From: Finlay Gardner <Finlay.Gardner@arun.gov.uk>
Sent: 06 March 2020 11:10
To: Planning.Responses <Planning.Responses@arun.gov.uk>
Subject: FW: LU/370/19/HH

From: chris barrow [REDACTED]
Sent: 06 March 2020 11:03
To: Finlay Gardner <Finlay.Gardner@arun.gov.uk>
Cc: Arun Windows & Supplies [REDACTED]
Subject: Re: LU/370/19/HH

On 5 Mar 2020, at 18:35, Finlay Gardner <Finlay.Gardner@arun.gov.uk> wrote:

EXT^N To BOUNDARIES. FLUSH.
SCALE 1:500

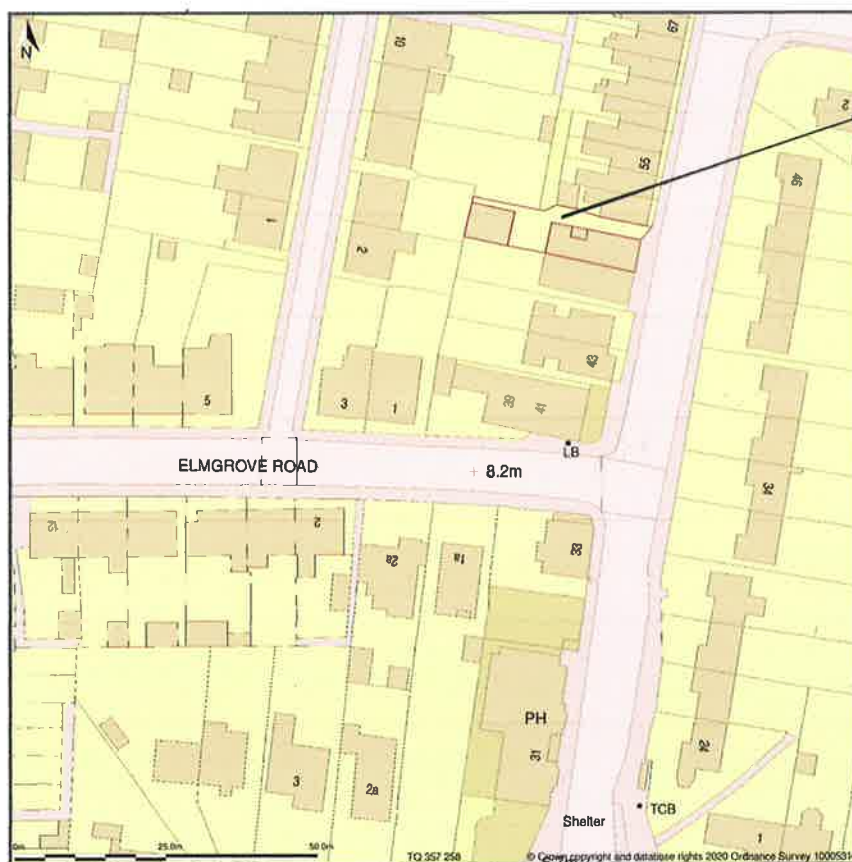
The block plan needs to be updated to show the first floor side extension to the office/flat. There needs to be clarification to the plans as to whether the first floor is used as an office or as a residential unit (flat) this then needs to be shown throughout.

Existing Ground Floor Plan
(1:100)

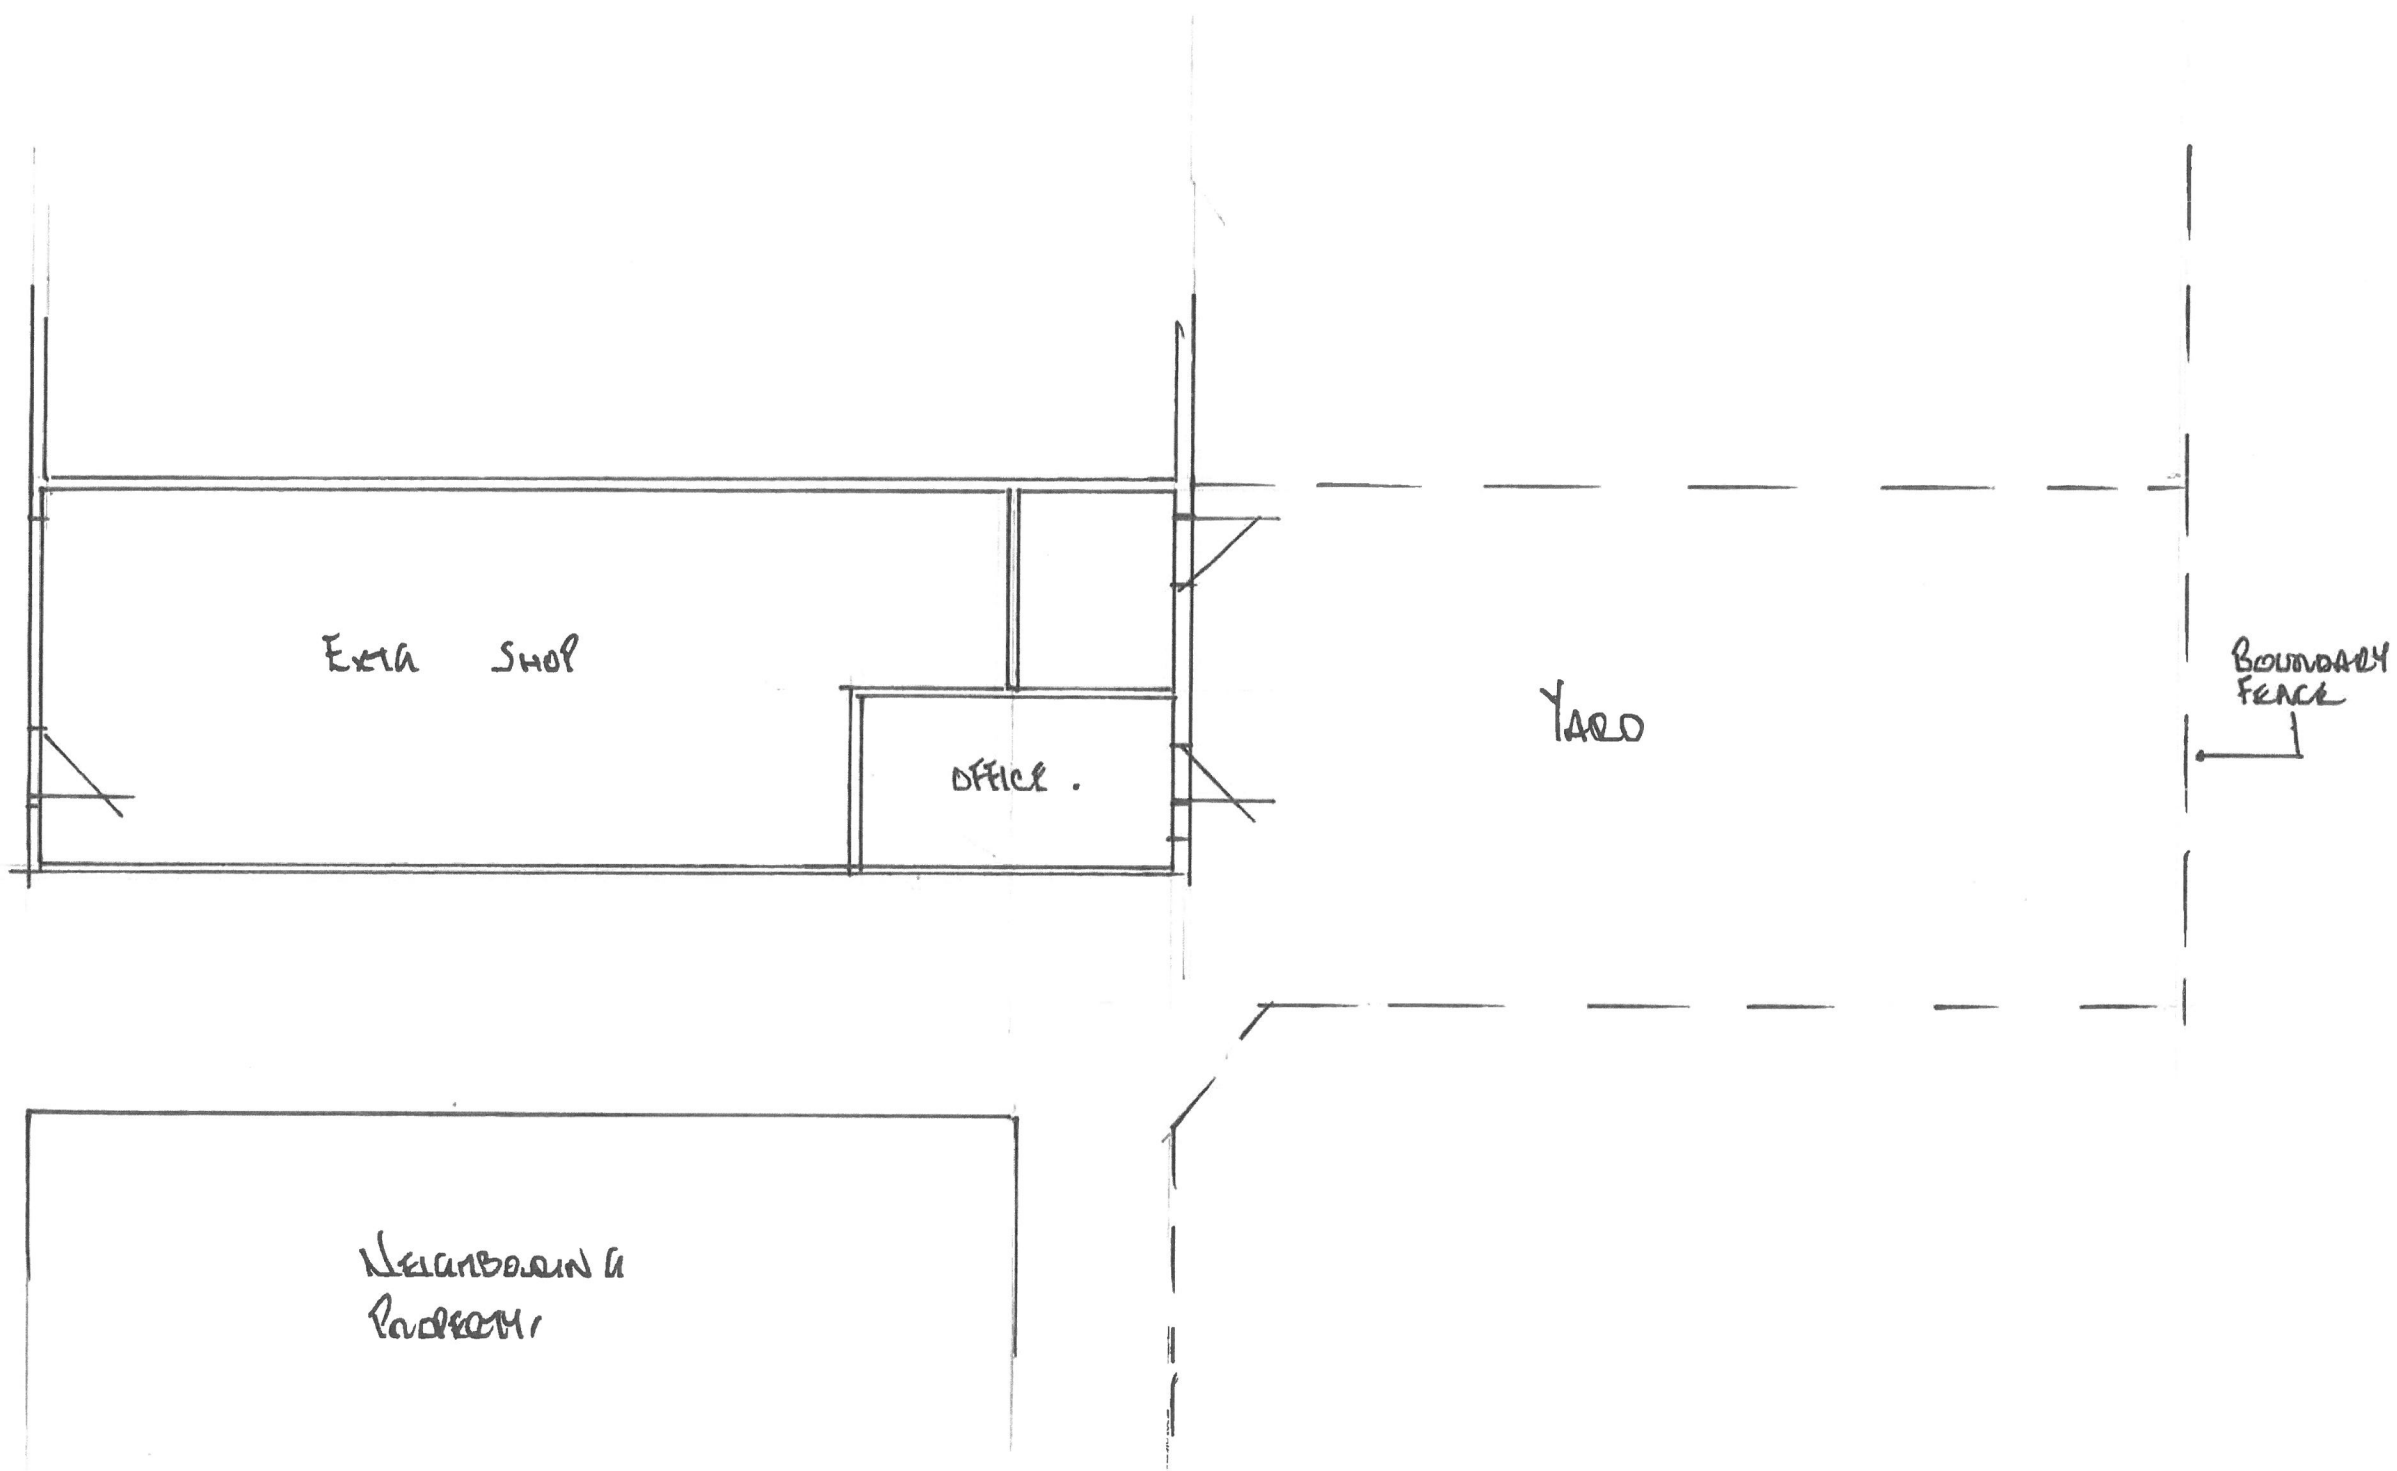
- The window sizes need checking.
- Flat/office needs to be clarified.

ALL AS EXISTING.
1:100.

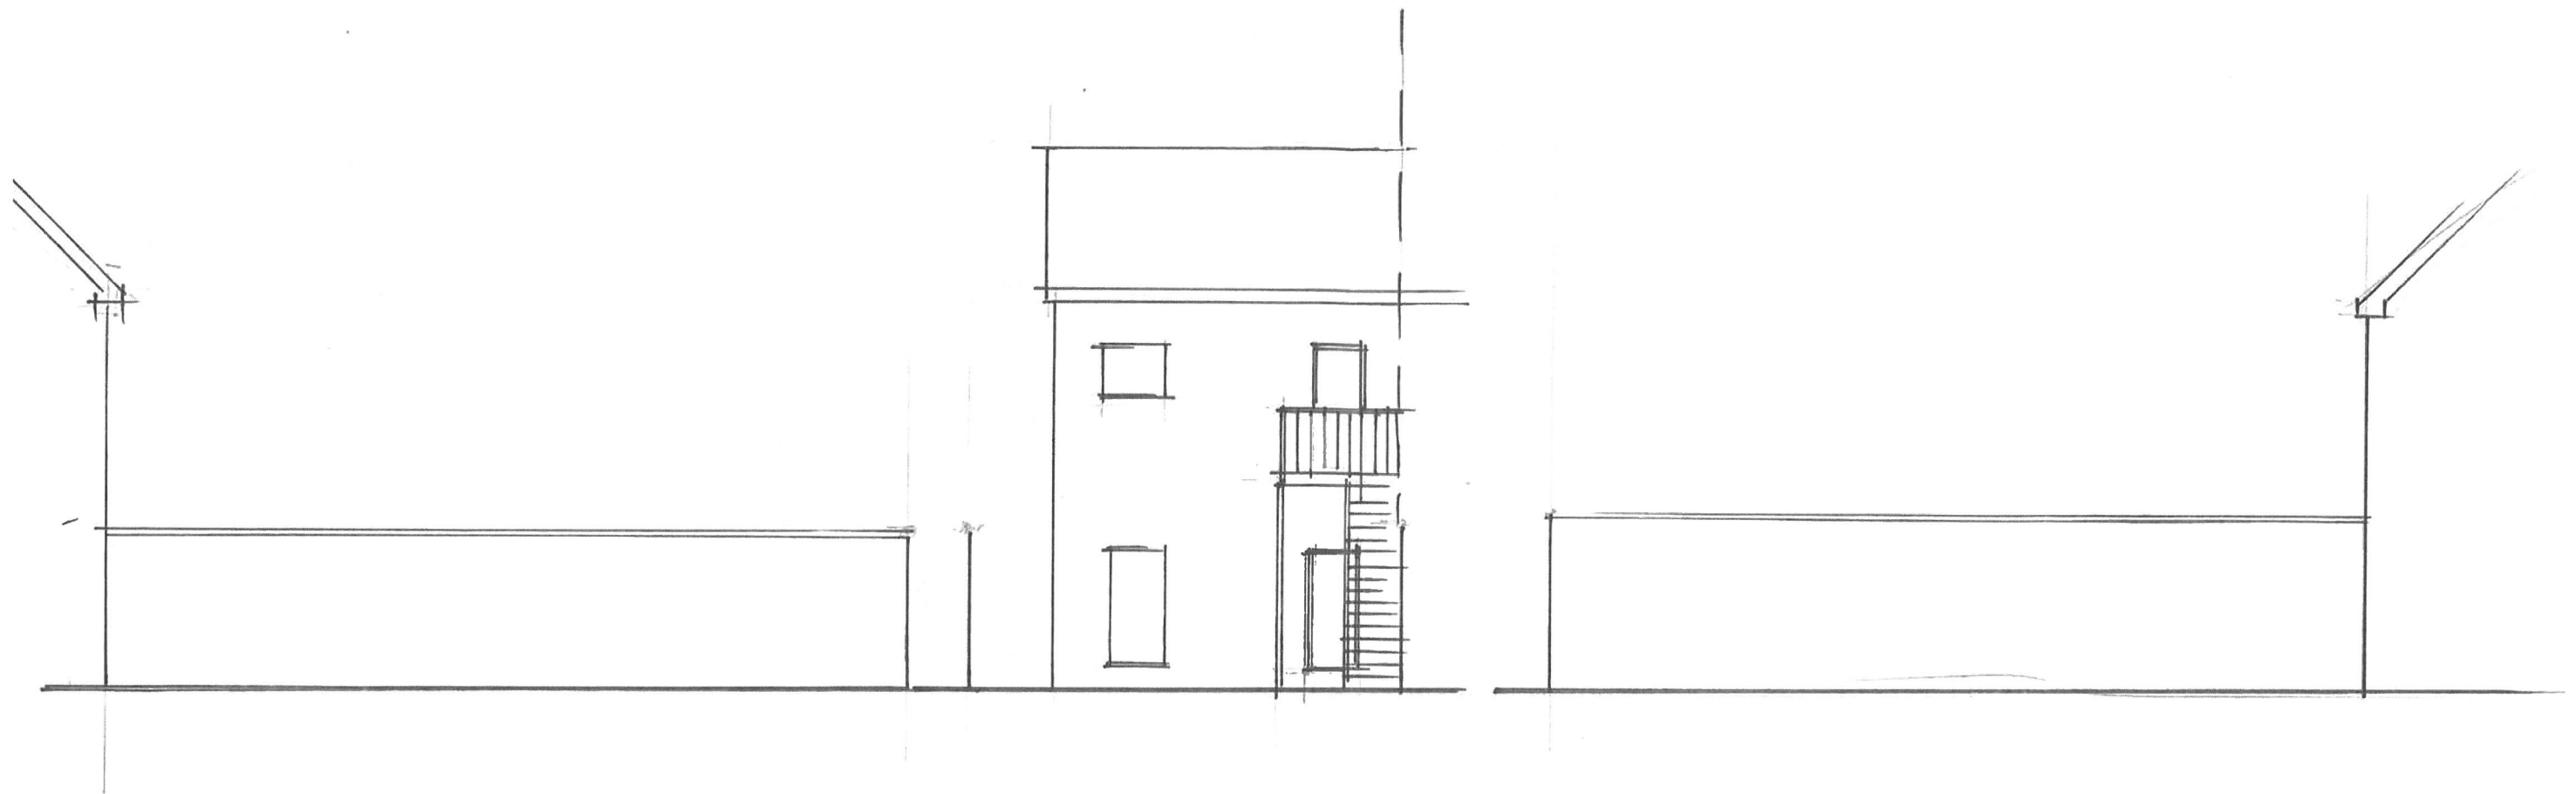
- Measurements need to be put in as not scaled correctly.
- The lean to roof needs to be shown.

PROPOSED GROUND FLOOR PLAN.
(1:100)

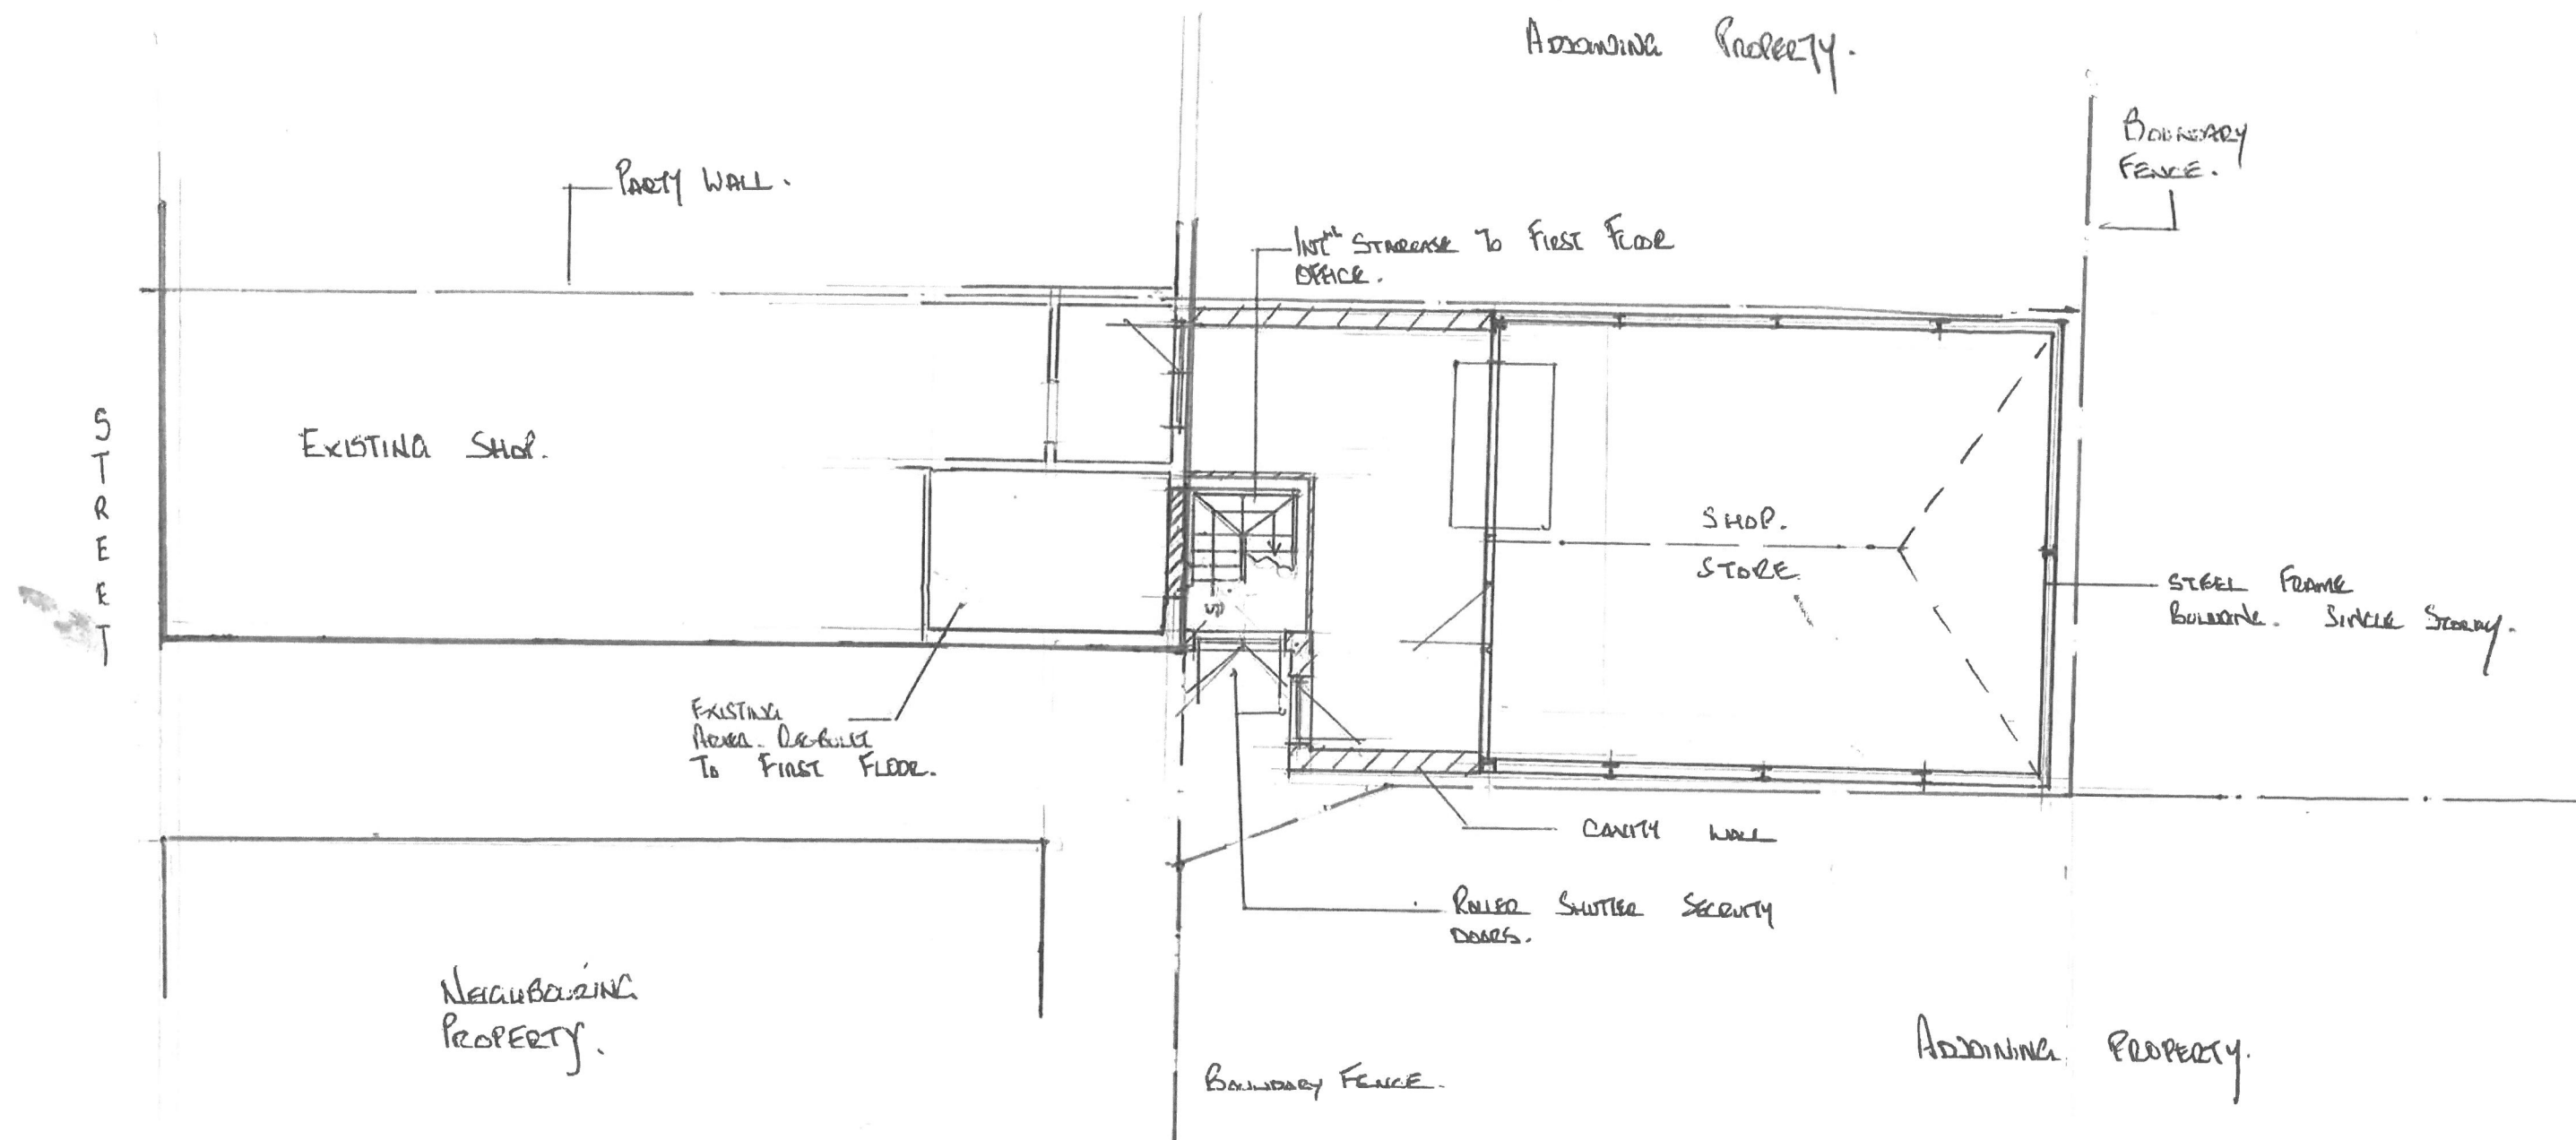
- The roof is currently shown to be overhanging the boundary to the north.
- The roof lights need to be shown.
- There is also no access currently shown to the proposed store.

[1:100]
[As Proposed.]

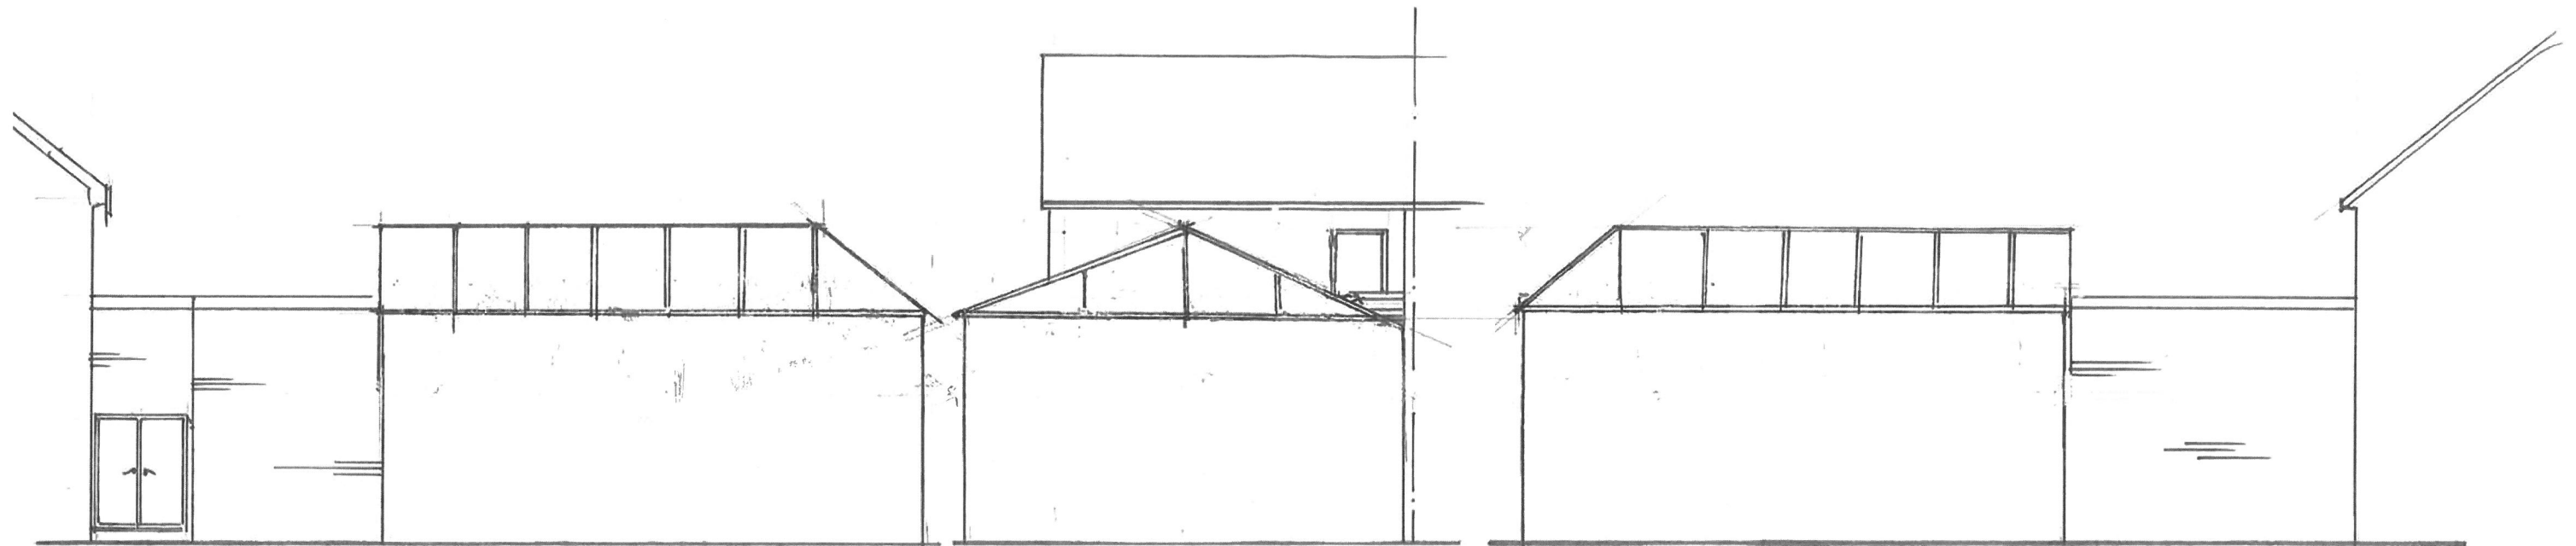
- There needs to be a title to the drawings (Proposed Elevations Scale 1:100).
- North and South elevations need to have the existing pitched roof shown (the one above the flat).
- The front elevation roof shape needs to be North to South (with the gables not visible).
- The North elevation needs to have the dotted line to show the floor level.
- The open area at the first floor needs to be labelled clearly and dimensions added to show the dwarf wall and then fencing above.
